# CITY OF ALBUQUERQUE

August 11, 2022

**Re: Restaurant Depot  
1901 Menaul Blvd NE  
Traffic Circulation Layout  
Engineer's 06-30-2022 (H15-D068)**

C2.0

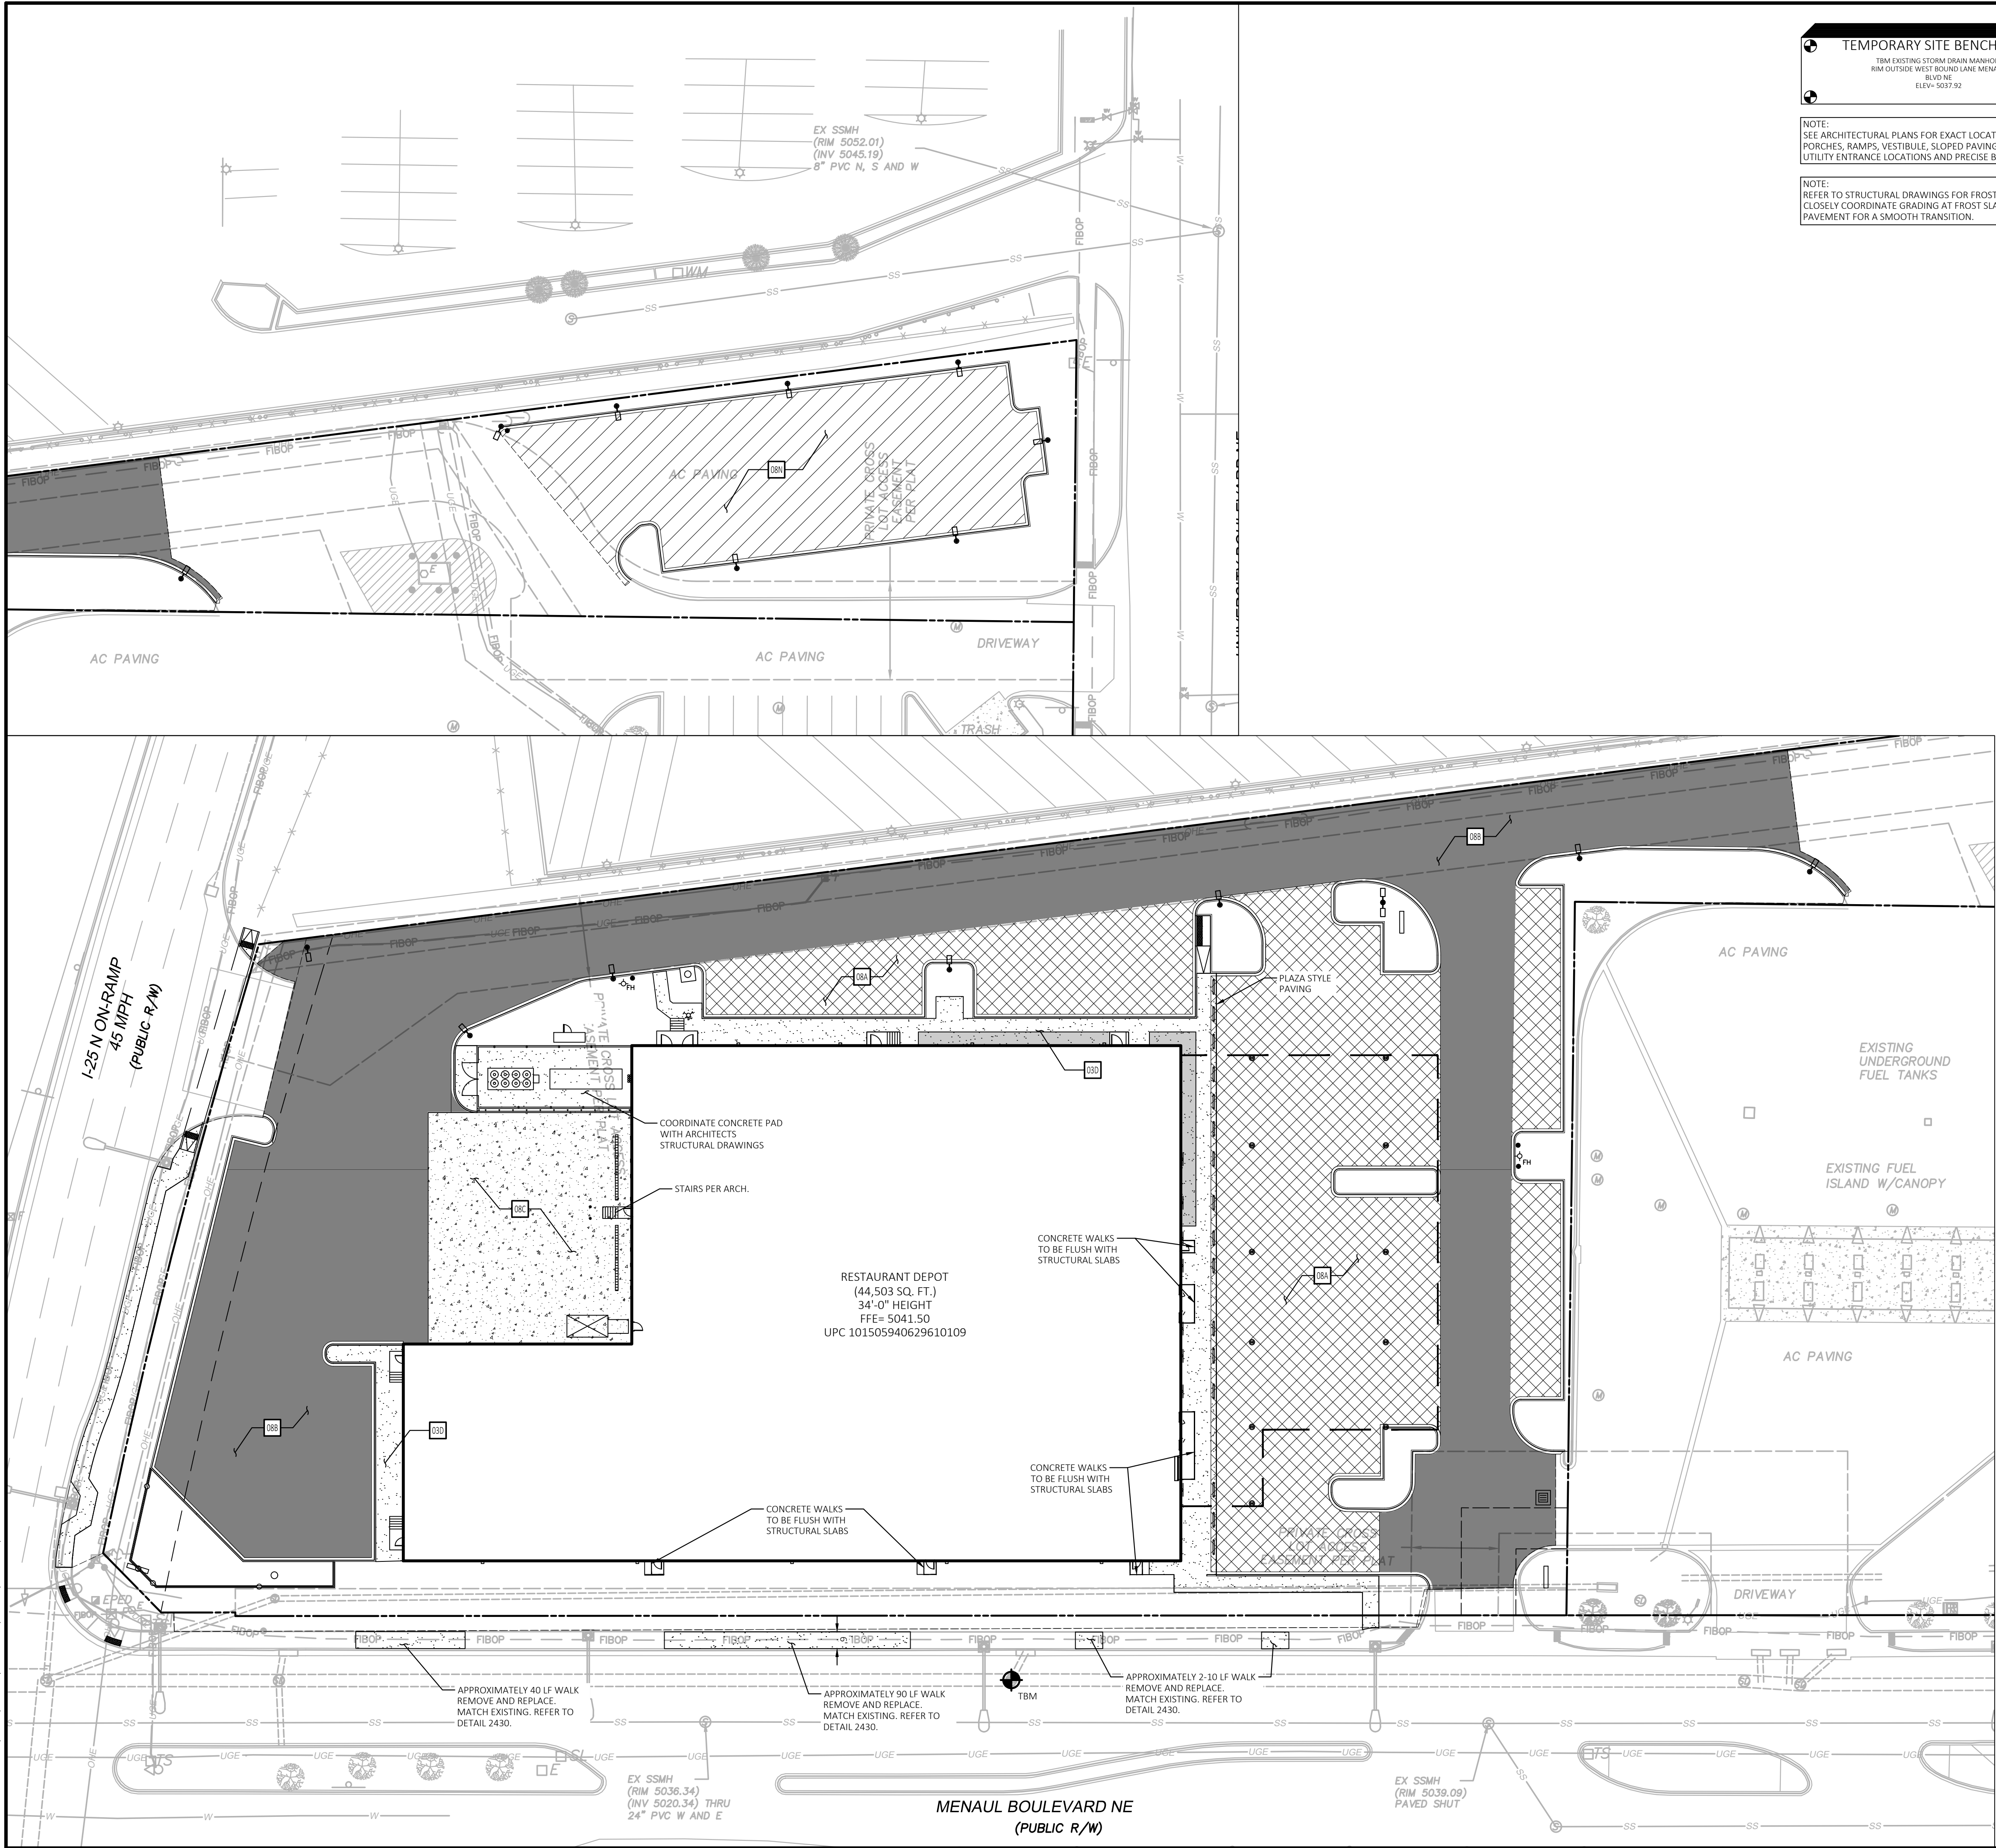
1. Listed are the number of parking spaces required by the IDO as well as the proposed number of parking spaces including bicycle and motorcycle parking.

**Coordinate/discuss with Zoning.**
2. You will need to coordinate with NMDOT on drive entrance modification/design fronting I-25 Frontage Roadway.
3. Details/reference sheets will need to be provided for all proposed infrastructure, pavement markings, signage etc and constructions with references (not all are addressed). All striping/stop bar will need to be located on private property.

4. **Unversity Blvd Frontage:**
  - All existing ramps will need to be current/updated ADA accessible. Please verify current ADA condition and provide construction notes to comply with this condition.

5. Do you need ramps on the ADA access aisles? Explain because you line type across the ADA stalls are not define whether the sidewalk is flush with parking lot pavement or curbing.

6. The ADA accessible parking sign must have the required language per 66-7-352.4C NMSA 1978 **"Violators Are Subject to a Fine and/or Towing."** Please call out detail and location of signs.

7. The ADA access aisles shall have the words **"NO PARKING"** in capital letters, each of which shall be at least one foot high and at least two inches wide, placed at the rear of the parking space so as to be close to where an adjacent vehicle's rear tire would be placed. (66-1-4.1.B NMSA 1978)

8. All public ADA curb ramps must be **updated to current standards** and have truncated domes installed. Please verify this concern.
9. Motorcycle parking spaces shall be designated by its own conspicuously posted upright sign, either free-standing or wall mounted per the zoning code.

11. Bicycle racks shall be sturdy and anchored to a concrete pad.
12. A 1-foot clear zone around the bicycle parking stall shall be provided.
13. Bicycle parking spaces shall be at least 6 feet long and 2 feet wide.

14. List radii for all curves shown; for passenger vehicles. Radius for delivery trucks, fire trucks, etc. is 25 ft. or larger. **Minimum internal radii's 15 ft.**

15. Per the DPM, a 6 ft. wide ADA accessible pedestrian pathway is required from the public sidewalk to the building entrances. Please clearly show this pathway and provide details.

16. Per DPM, a 6 ft. wide ADA accessible pedestrian pathway is required from the ADA parking stall access aisles to the building entrances. Please clearly show this pathway and provide details.

22. Unused curb cuts must be replaced with sidewalk and curb & gutter **(If applicable)**. A build note must be provided referring to the appropriate City Standard drawing (2430 & 2415A).
